**From:** Tim Townsend [REDACTED]  
**Sent:** 02 April 2026 11:26  
**To:** Williams, Chris; Hannah Kersley  
**Cc:** Blacker, Andrew; Steven Shaw  
**Subject:** RE: AL/11/24 - Land at Westergate - Follow-up points following today's meeting

**From:** Tim Townsend [REDACTED]  
**Sent:** 24 March 2026 14:04  
**To:** Blacker, Andrew [REDACTED] Williams, Chris [REDACTED]  
**Subject:** AL/11/24 - Land at Westergate - Follow-up points following today's meeting

Figure 1 – 2031 Do-Something AM Peak Traffic Flows

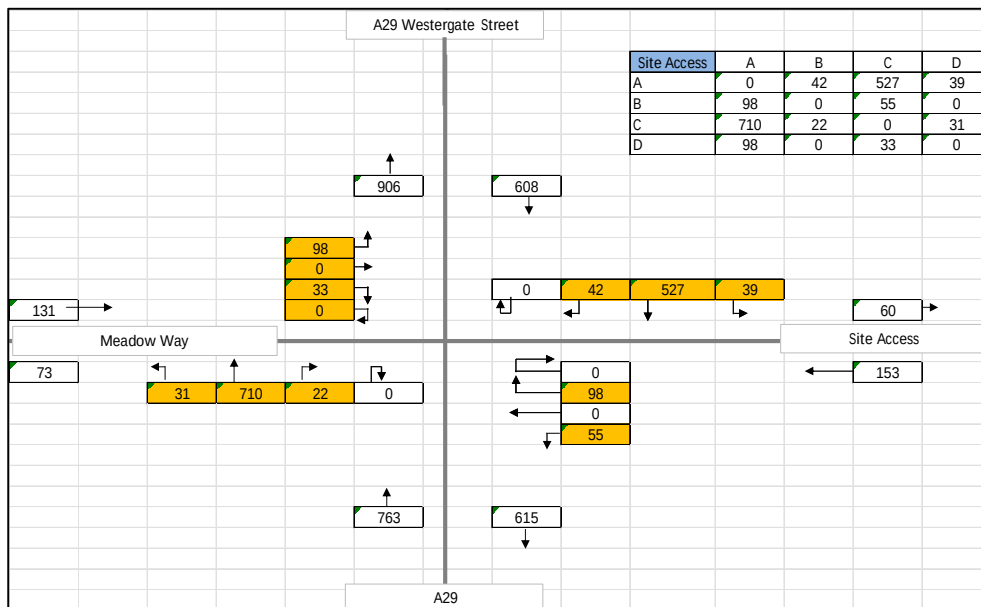
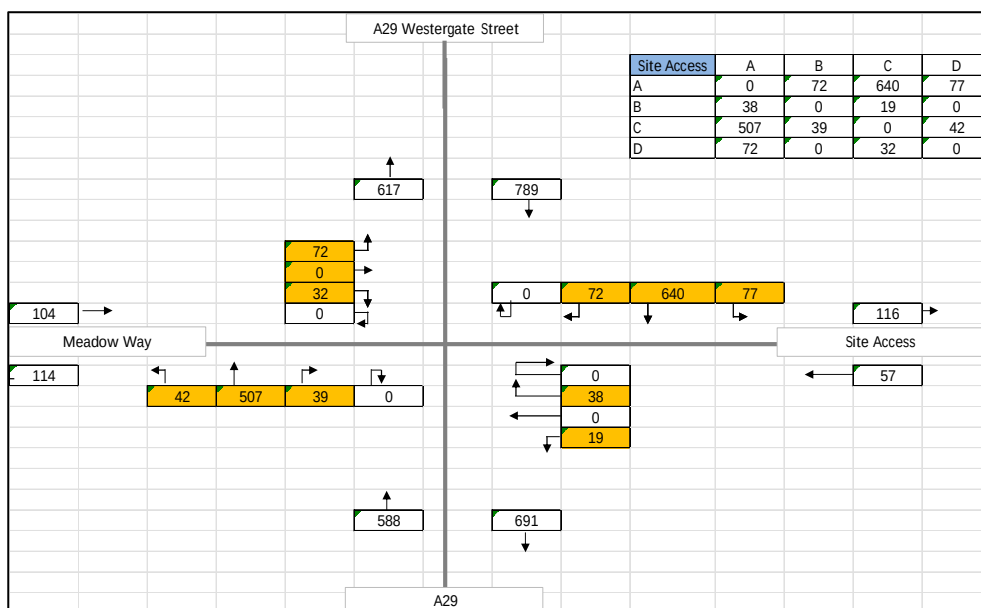
3. *Modelling* – (previous comment repeated) - During peak periods, there is still concern that in the event that the railway crossing gates are closed and the southbound traffic queue on the existing A29 extends north of the proposed access junction onto A29, that vehicles attempting to leave the site might be blocked by a vehicle attempting to turn left out of the site, leading to backing-up within the site. Without an additional

exit lane, this will happen. The turning flows shown in the TAA appear low and I am concerned that blockages might be frequent based on the data provided and additionally, if flows end up being higher in practice. Can you review the turning flows again for the different scenarios in the peak periods and submit these for me to look at. And, is there the opportunity to provide an additional exit lane if additional land (third party or other) were to be used? I think you might have replied to this previously but either-way, please would you send me your reply. *The latest modelling information shows that the junction should work based on the future traffic scenarios assessed and including the associated interventions provided (e.g. loops in the carriageway to monitor and react to railway crossing closures and other timings controlled by MOVA etc), thereby minimising chance of the junction becoming blocked. Of course, only 100 homes can come forward until Phase 1 of the new A29 is complete and open to traffic, as-per the conclusions in the Pell Frischmann report into interim traffic impact matters. You have signed-up to this already in previous correspondence. This must form part of any permission granted (a Grampian-style condition is recommended). Once Phase 1 of the A29 is open, then the modelling indicates that the remainder of the homes could then be developed in traffic terms (i.e. the remaining 300). However, an important point to bear in mind is that the creation of the aforementioned bridge will also assist with movement in and out of the development site by encouraging trips on-foot and by bicycle which will help with trip rate reduction through the junction onto the existing A29.*

3. *Modelling* – (previous comment repeated) - During peak periods, there is still concern that in the event that the railway crossing gates are closed and the southbound traffic queue on the existing A29 extends north of the proposed access junction onto A29, that vehicles attempting to leave the site might be blocked by a vehicle attempting to turn left out of the site, leading to backing-up within the site. Without an additional exit lane, this will happen. The turning flows shown in the TAA appear low and I am concerned that blockages might be frequent based on the data provided and additionally, if flows end up being higher in practice. Can you review the turning flows again for the different scenarios in the peak periods and submit these for me to look at. And, is there the opportunity to provide an additional exit lane if additional land (third party or other) were to be used? I think you might have replied to this previously but either-way, please would you send me your reply.

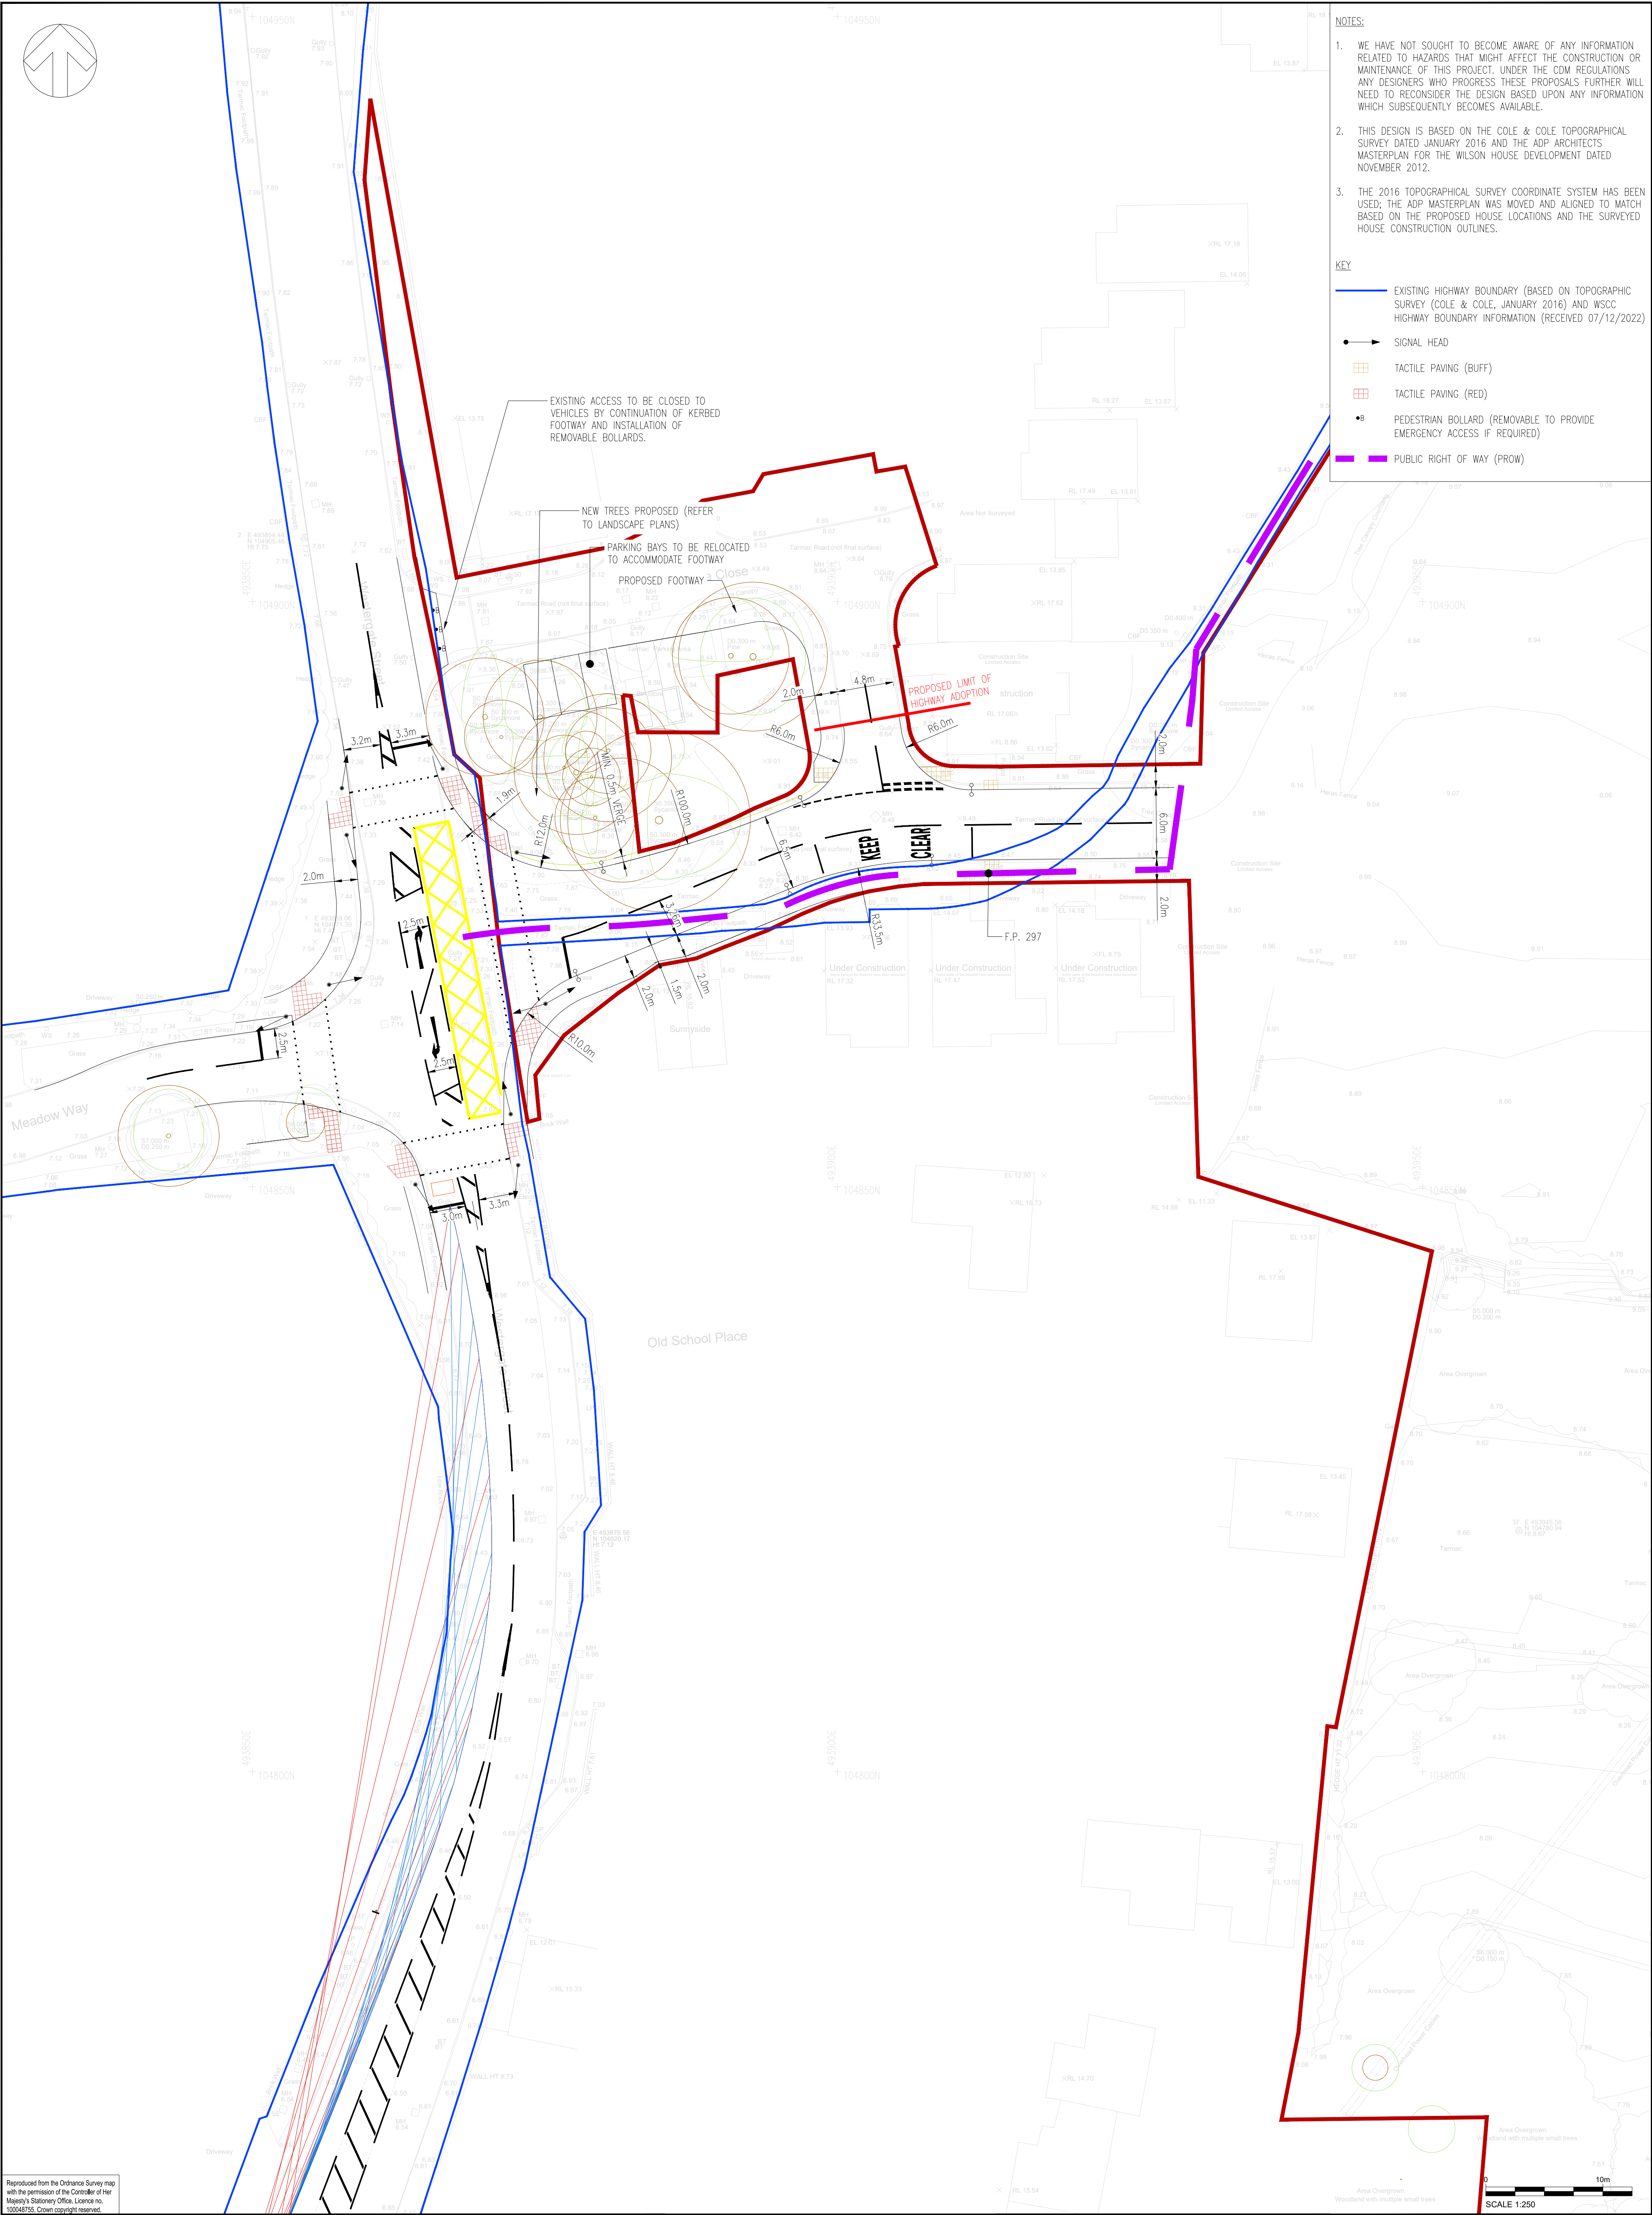
4. *Closure of Pine Close – Engineering detail of closure required. You mentioned bollards for this but having thought about it further after the meeting, I'm not sure if these would work. I suspect that it would be reserved for emergency access and access on foot and by bicycle. Please would you give this a bit more thought and perhaps move away from bollards (albeit accepting that day-to-day access by vehicles should be prevented which will probably still require a bollard (or bollards) being located across it). The changes shown in your technical note are noted. I still think it needs a bit more work and I would like to see some form of cycle access from the A29 (it might be that a cycle 'off' marking could be applied to the carriageway on the A29 to direct cyclists into the development). You would need to check with LTN 1/20 to see what is or isn't possible. With regard to bollards and kerbing treatments, clearly if cycles are going to be able to enter the site, a ramped/dropped kerb arrangement would be required. Of course, tactiles and signage for pedestrians and cyclists will need to be incorporated, too. As for the bollards, these would need to meet with the emergency services requirements (plus whatever LTN 1/20 says, too). However, I do agree that a continuous footway would be the preferred way to 'close' the entrance.*

4. *Closure of Pine Close* – Engineering detail of closure required. You mentioned bollards for this but having thought about it further after the meeting, I'm not sure if these would work. I suspect that it would be reserved for emergency access and access on foot and by bicycle. Please would you give this a bit more thought and perhaps move away from bollards (albeit accepting that day-to-day access by vehicles should be prevented which will probably still require a bollard (or bollards) being located across it).
